MEMORANDUM

TO: Nell Donaldson, Planner
FROM: David Senus, P.E. & Ashley Auger, E.I.T.
DATE: May 30, 2012
RE: Pomeroy Street Construction, Level I & II Site Plan Application

Woodard & Curran has reviewed the Level I Minor Residential Development Site Plan & Level II Final Site Plan Application for the single family residence and Pomeroy Street extension located off of Bancroft Street in Portland, Maine. The parcel was previously approved for a Site Plan and Conditional Use Permit in August of 2005 by the City for a single family residence with attached synagogue; however, these permits have since expired. The current amended project consists of developing a single family home, an outsale lot to be sold to Square One Construction Inc. for possible development, and construction of approximately 200 linear feet of Pomeroy Street.

SITE PLAN
LEVEL I-MINOR RESIDENTIAL DEV.
LEVEL II-ROAD IMPROVEMENTS
LAND OF
CHABAD LUBAVITCH OF MAINE INC.
POMEROY STREET
PORTLAND, MAINE

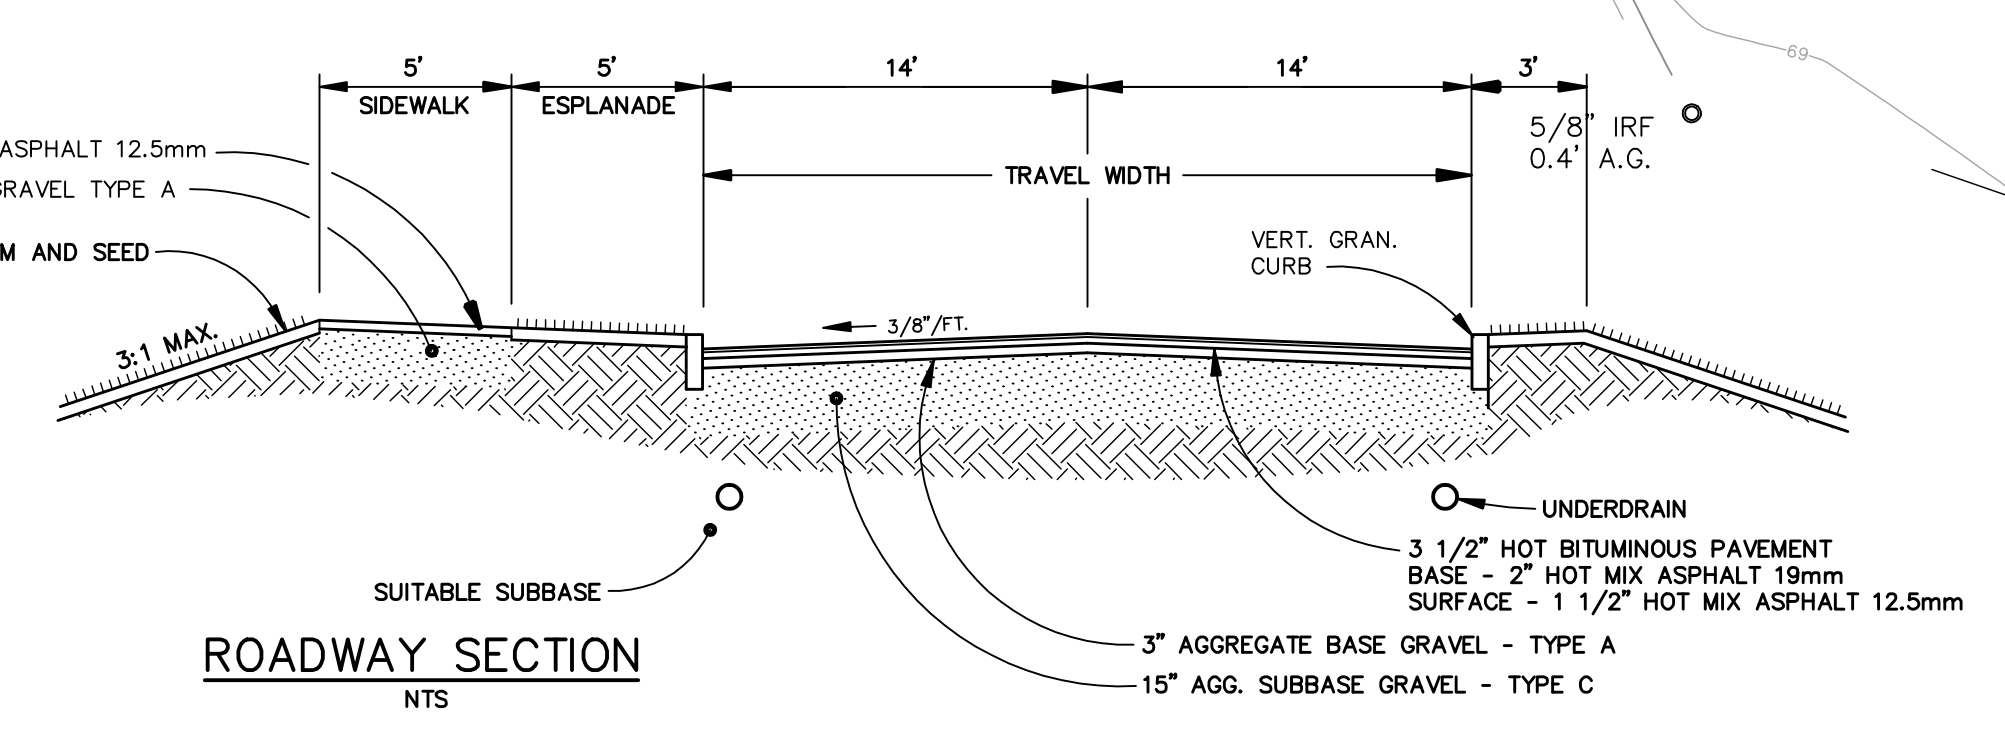
- 1) Proposed storm drain piping within the City ROW shall meet the material requirements noted in Section 2.5.2. of the City of Portland Technical Manual. The plans should note an acceptable storm drain pipe material or note acceptable pipe material options for storm drain pipe within the City ROW.

- 3) The Site Plan proposes two drainage pipe inlets located on either side of the residential driveway. These inlets have proposed invert elevations that are below the existing ground surface elevation, and are located in close proximity to existing wetlands. Surface and shallow groundwater associated with these wetland areas will likely enter the roadway drainage system through these inlets, affecting the hydrology of the adjacent wetland areas. Although review of wetland impacts will be performed by MaineDEP, the addition of this "non-contaminated" water source into a drainage system that discharges into the City's combined sewer is not allowed unless approved by the City Engineer (Section 2.1.1 of City of Portland Technical Manual).

- a) The Applicant proposes to discharge stormwater runoff from the developed site into the municipal combined sewer system. Per Section 2.1.1, rain water shall not be allowed to discharge into a sewer which conveys sanitary waste unless approved by the City Engineer.

ROADWAY SECTION
N.T.S.

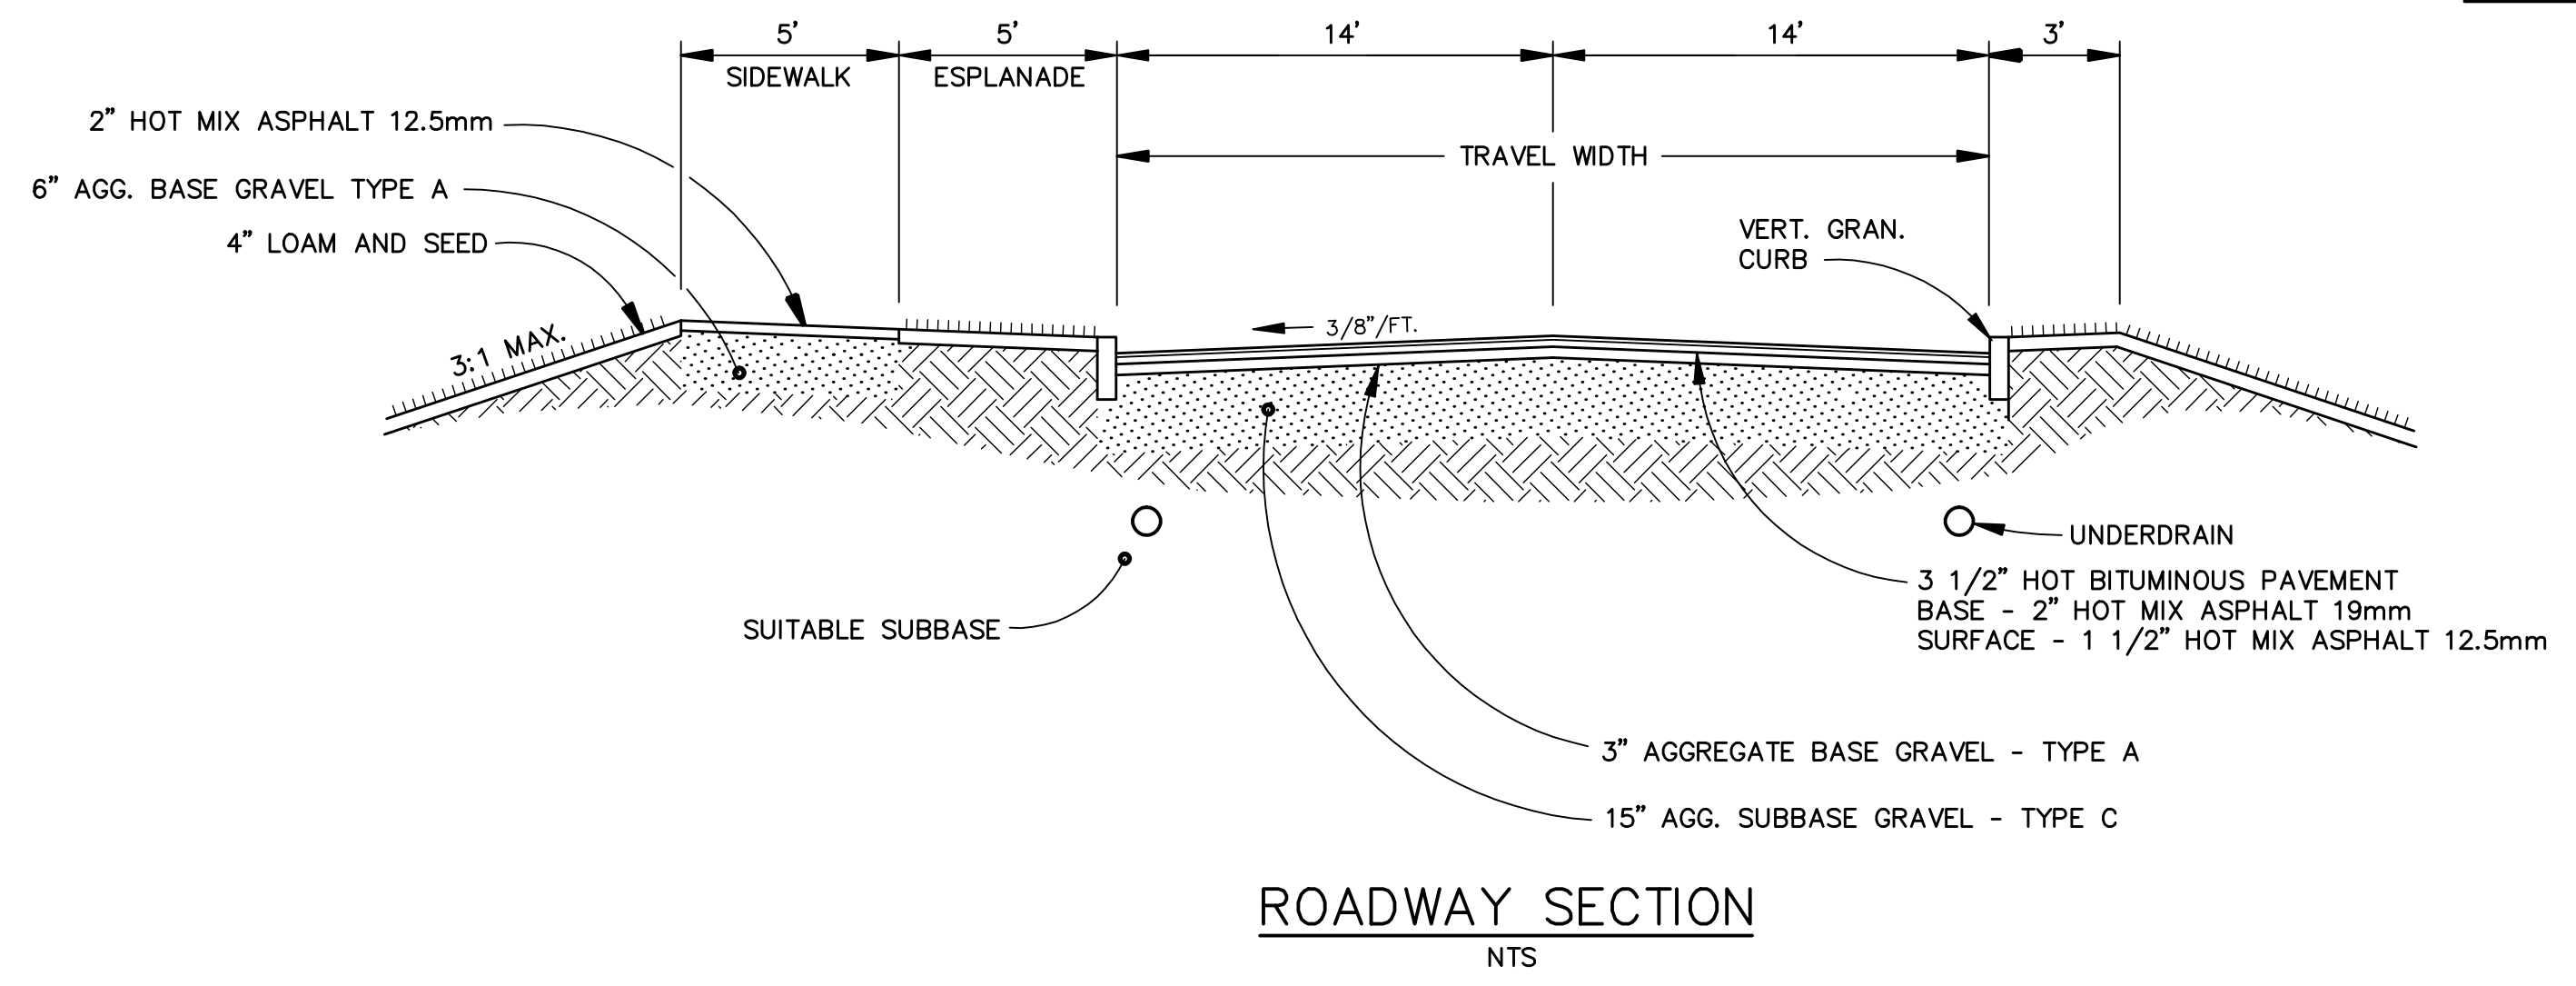
- 4) In accordance with Section 1 of the City of Portland Technical Manual:
 - a) The aggregate base course for a bituminous sidewalk should be 10" of Type B gravel per Figure I-12.

VERTICAL GRANITE CURB DETAIL
N.T.S.

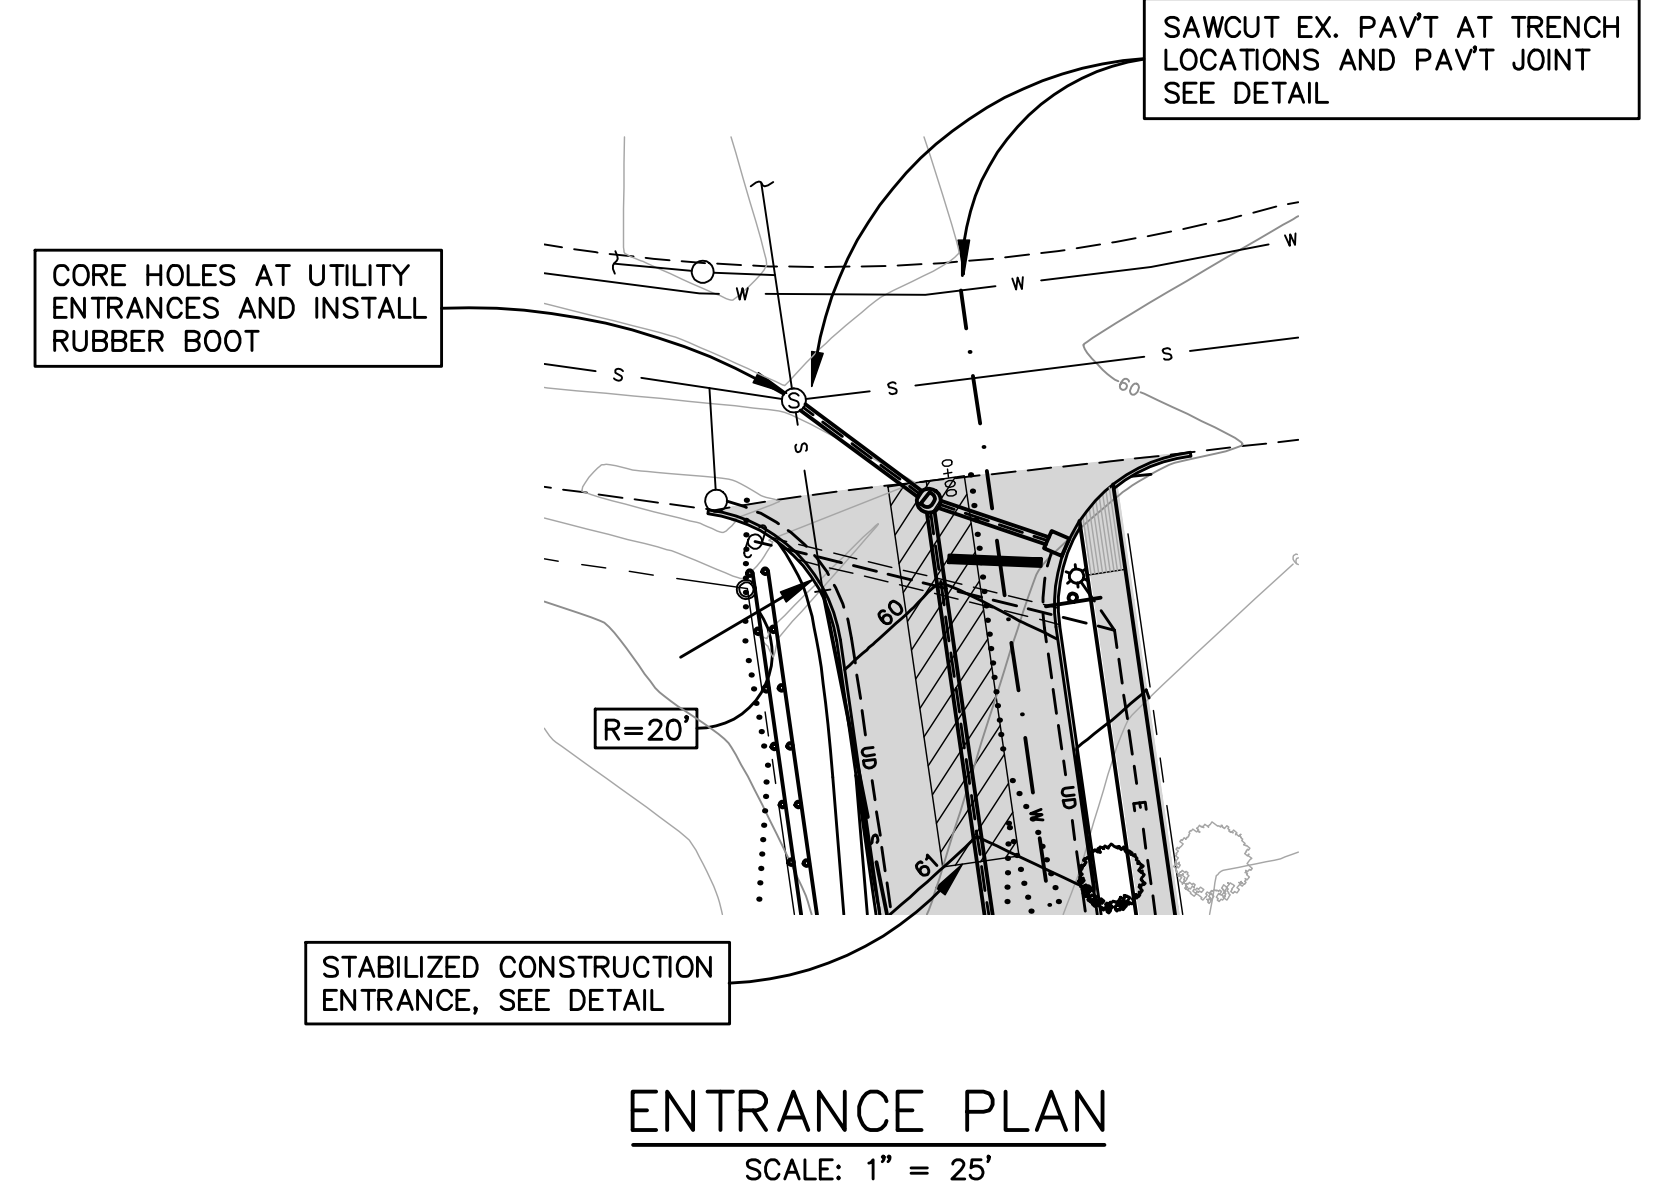
- b) Vertical Granite Curbing and Terminal Curb details should be per Figure I-16.
- 5) In accordance with Section 2 of the City of Portland Technical Manual:

PRE DEVELOPMENT
DRAINAGE PLAN
LAND OF
CHABAD LUBOBITCH OF MAINE INC.
POMEROY STREET
PORTLAND, MAINE

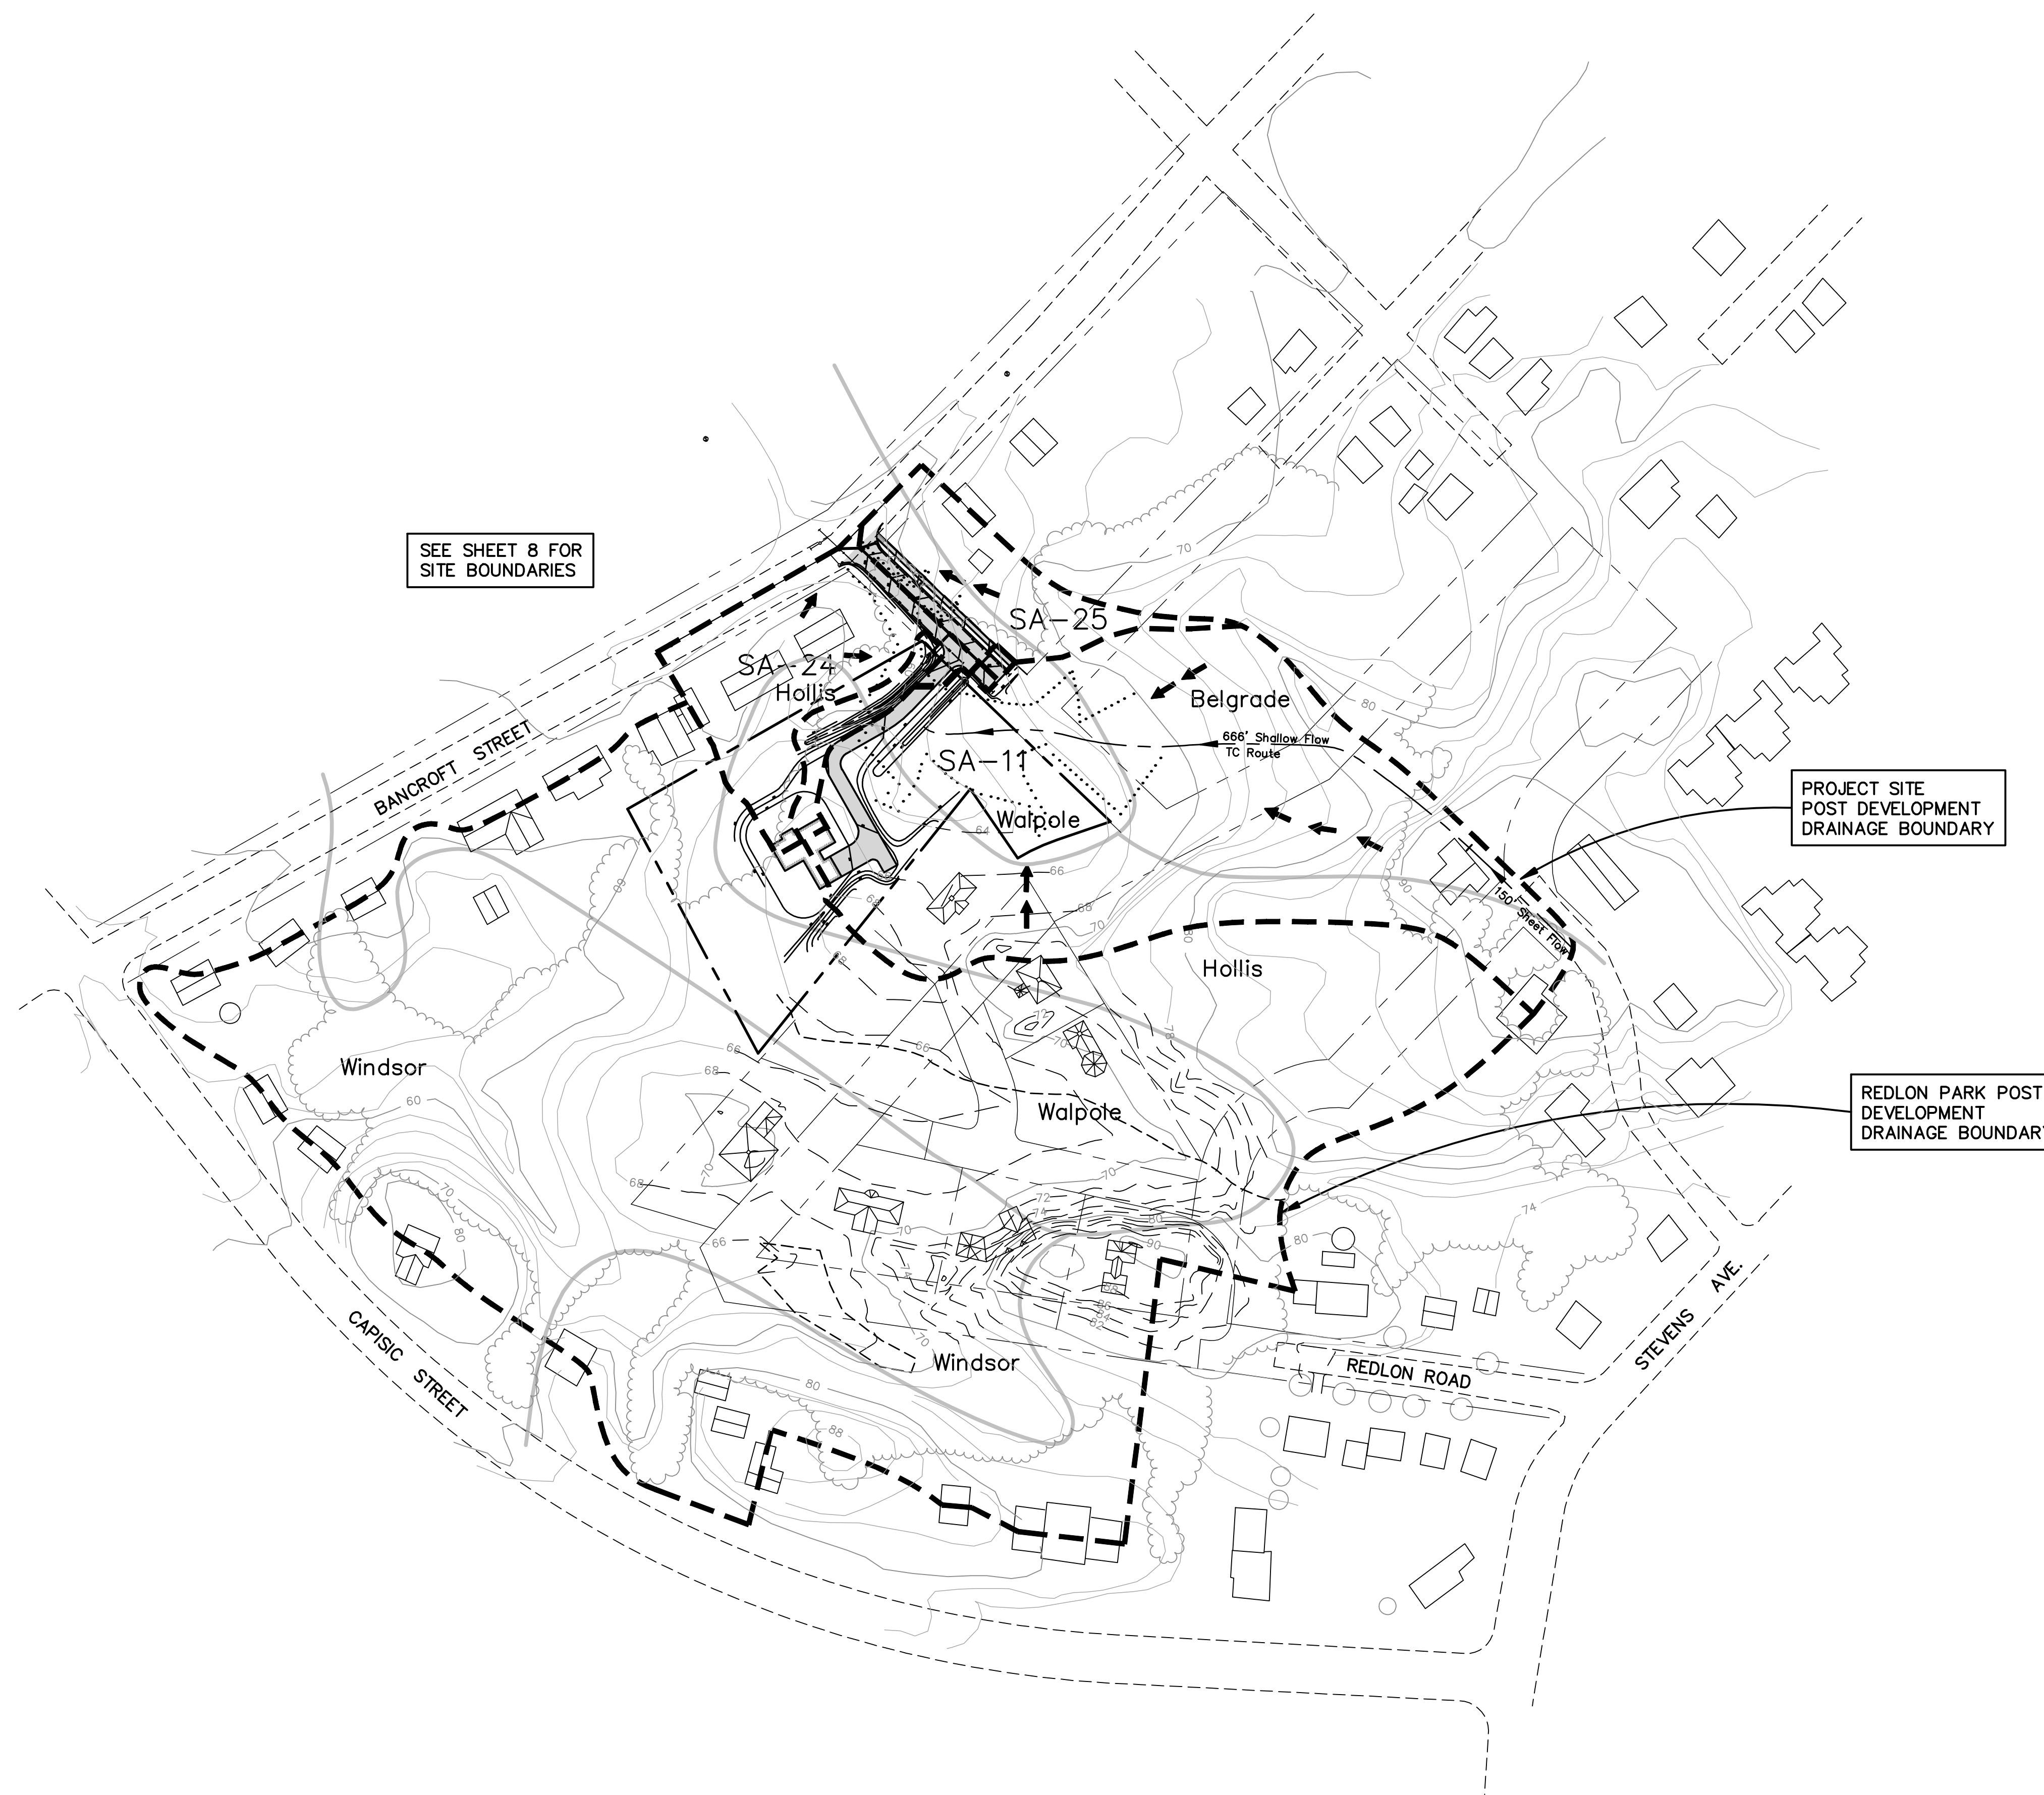
- i) The input parameters for Sheet Flow for SA-1 (Pre) and SA-11 (Post) should be the same, as this area will not change as a result of the project.
- 8) The Stormwater Management Plan will need to include a stormwater inspection and maintenance plan for all stormwater BMP's designed to meet the General Standards, developed in accordance with and in reference to MaineDEP Chapter 500 guidelines and Chapter 32 of the City of Portland Code of Ordinances.
